Fire Department

MEMORANDUM

7 October 2009

Re: 645 Congress Street

FA1.2

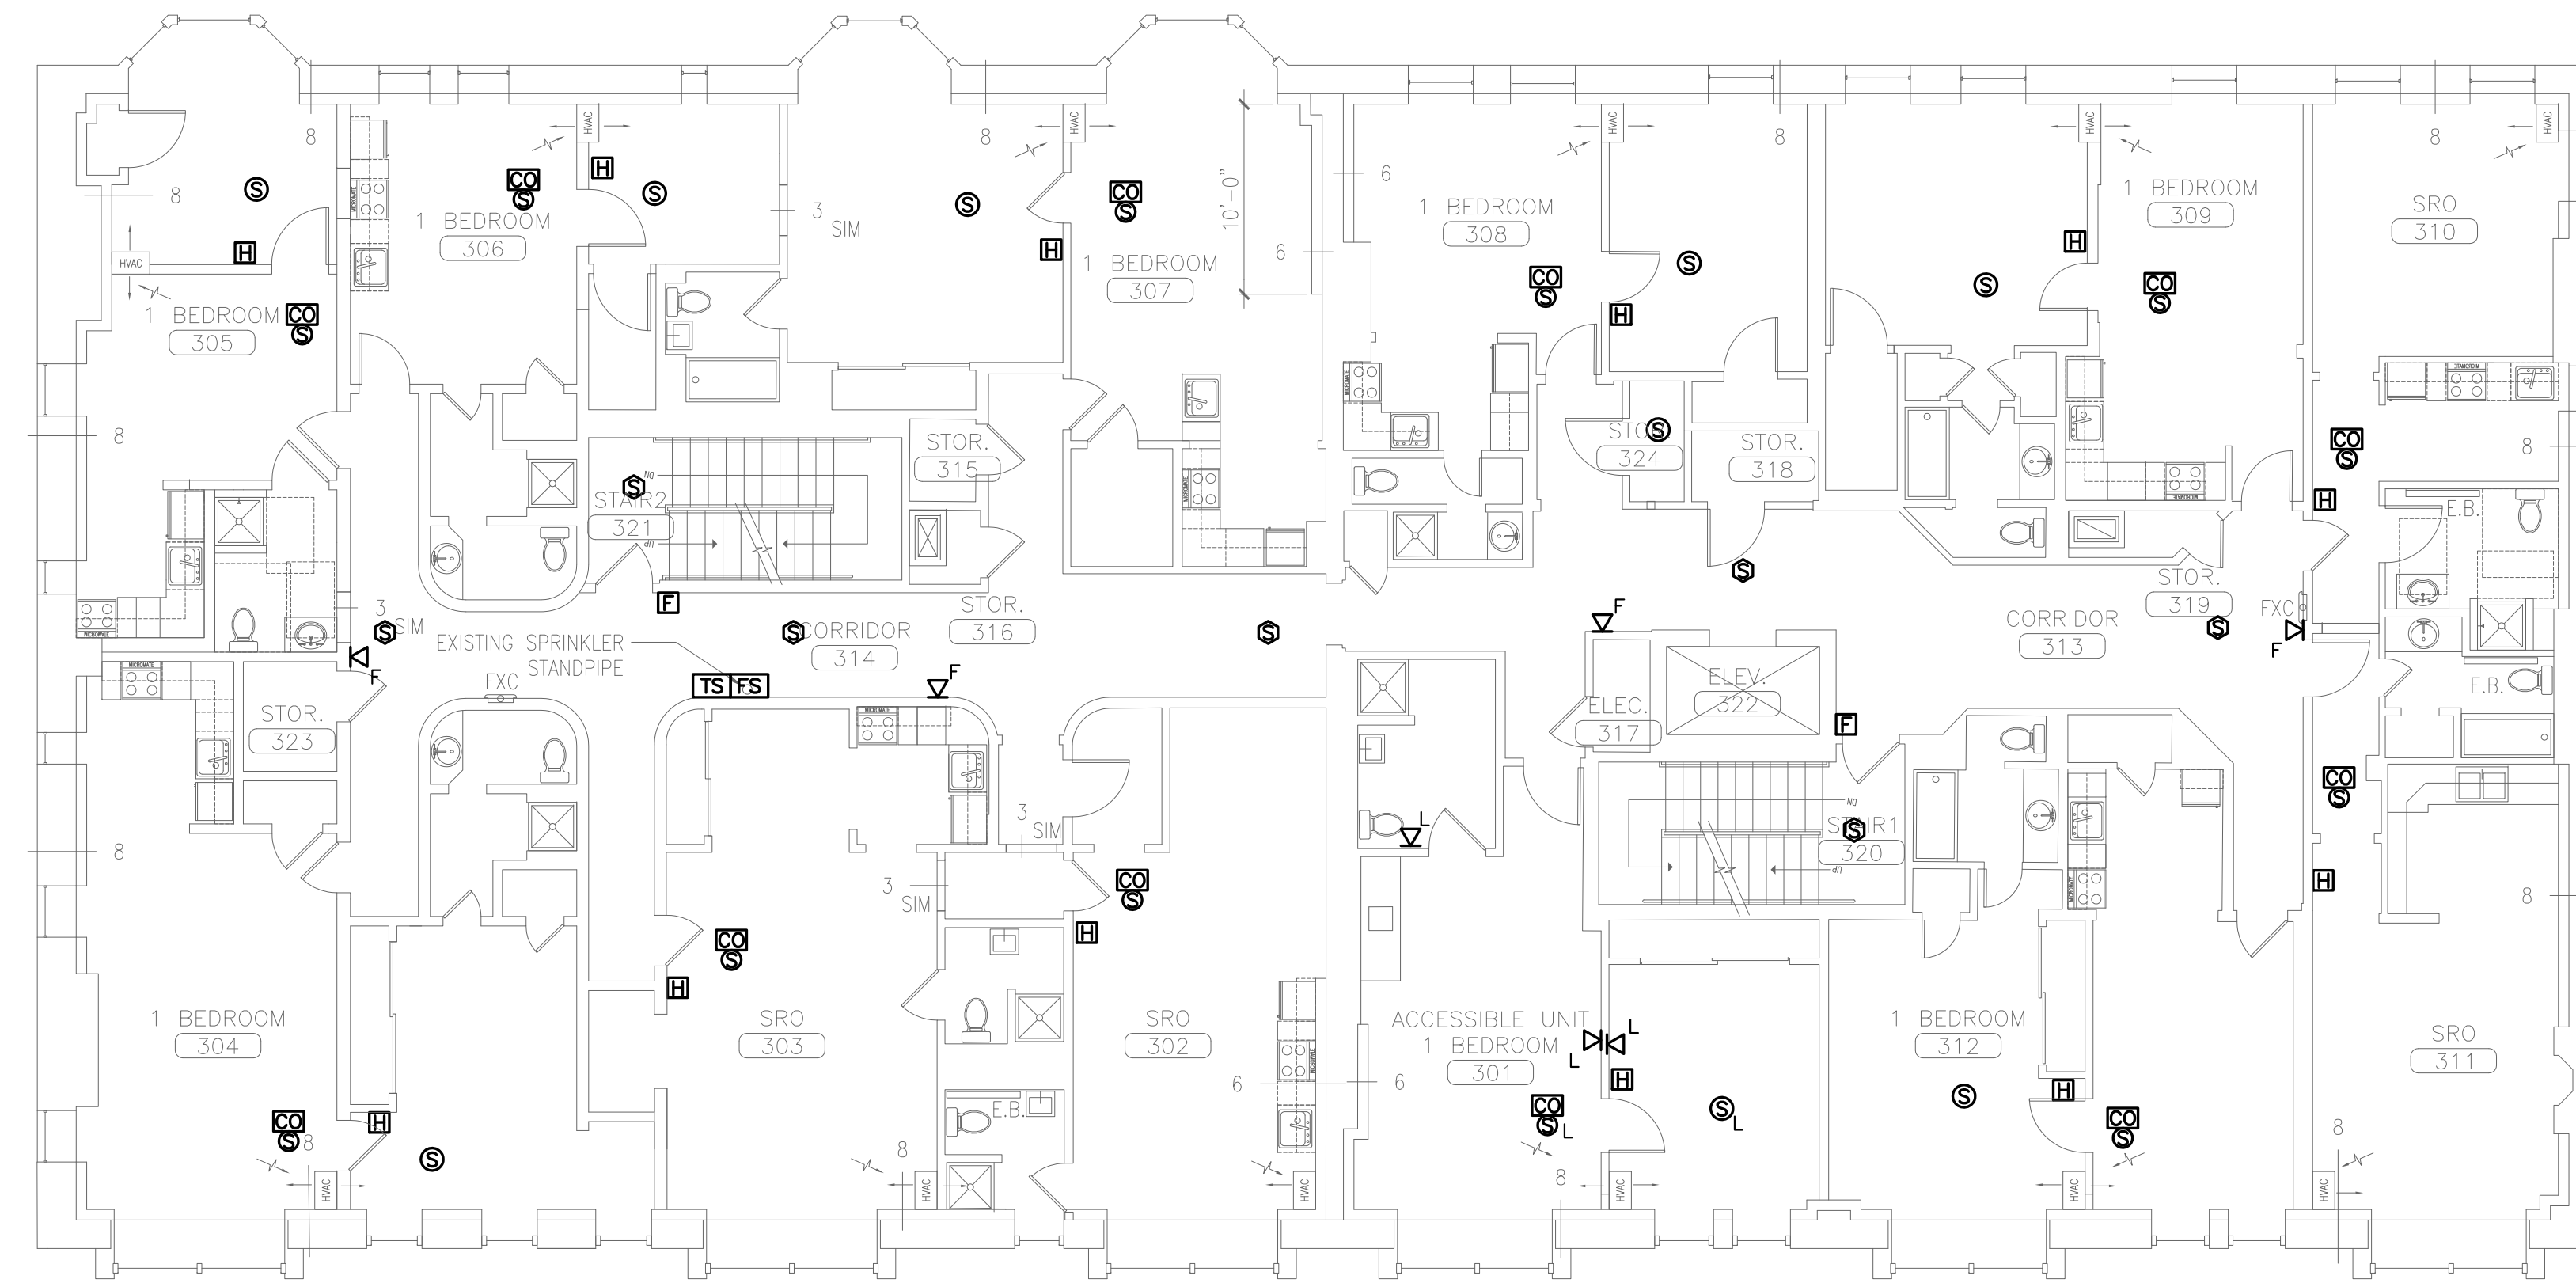
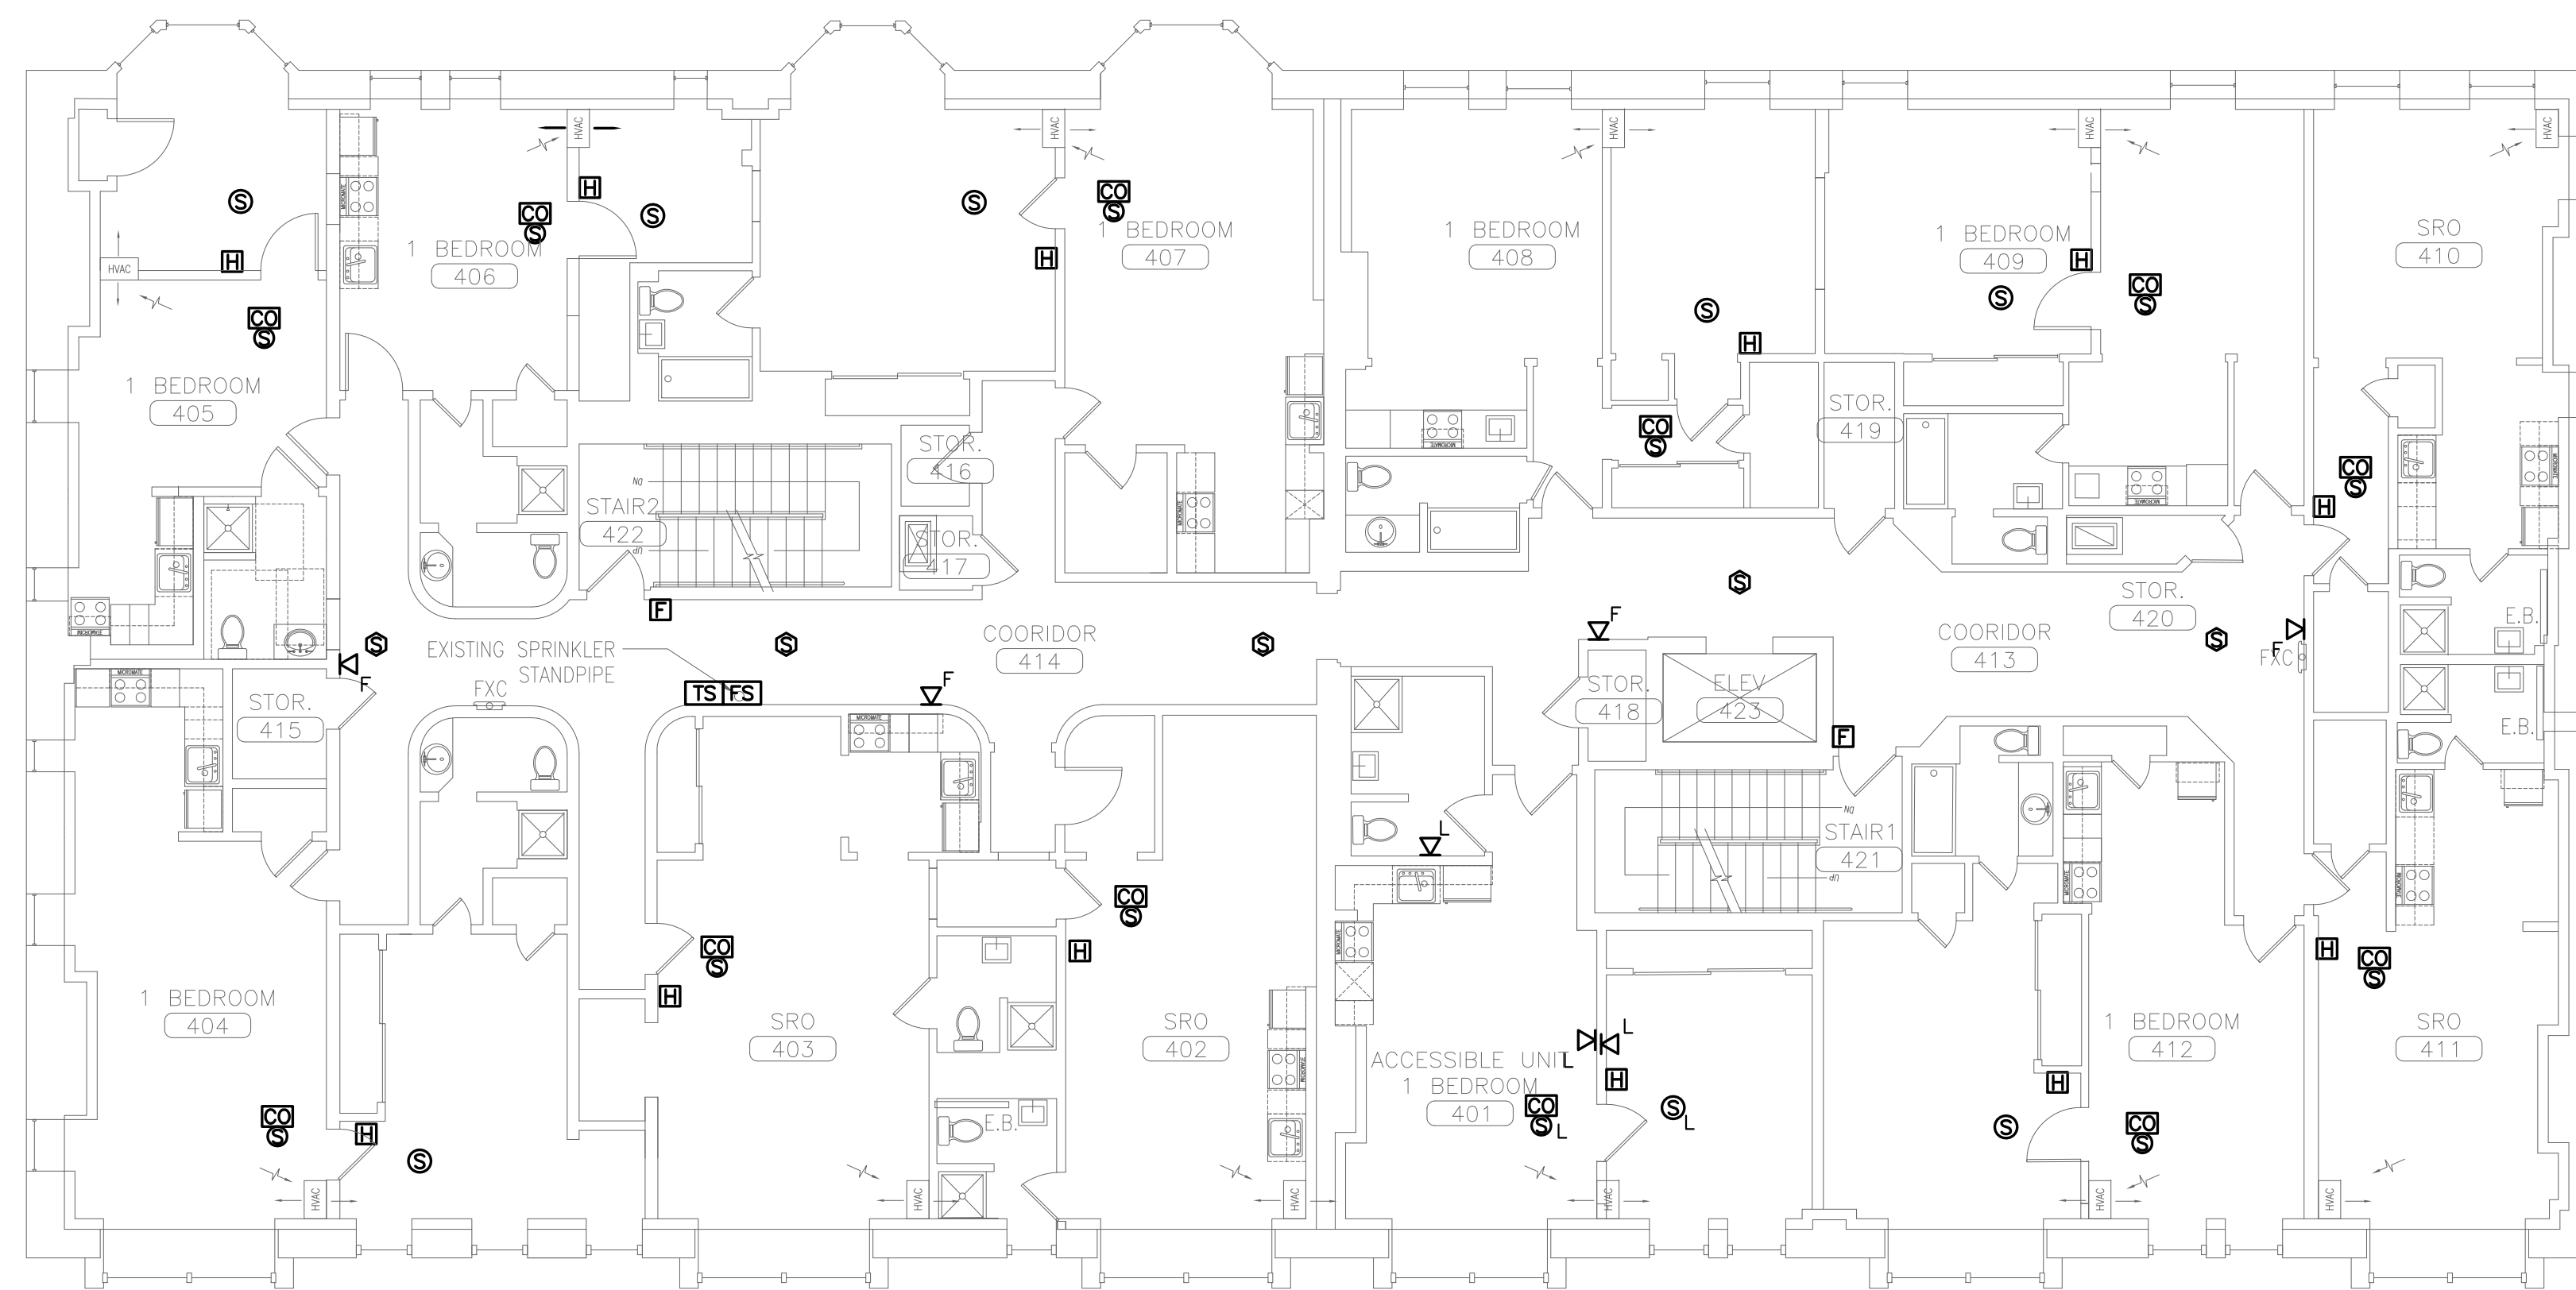
1. Because of the reuse of the existing building, certain existing fire alarm cable may be reused. All such cable shall be Fire Power Limited Plenum (FPLP).

2. In rooms where ceilings are sealed or the space above the ceiling is combustibile, all such cable shall comply with the National Fire Alarm Code, Article 760 of the National Electrical Code (NEC) and current City Code.

3. Where wiring is added or replaced, it shall comply with the National Fire Alarm Code, Article 760 of the National Electrical Code (NEC), and current City Code.

4. It must be verified there is two notification circuits on each floor, providing that every other notification appliance is on a different circuit.
5. An inspection of all fire alarm cables shall be performed prior to any close-in.
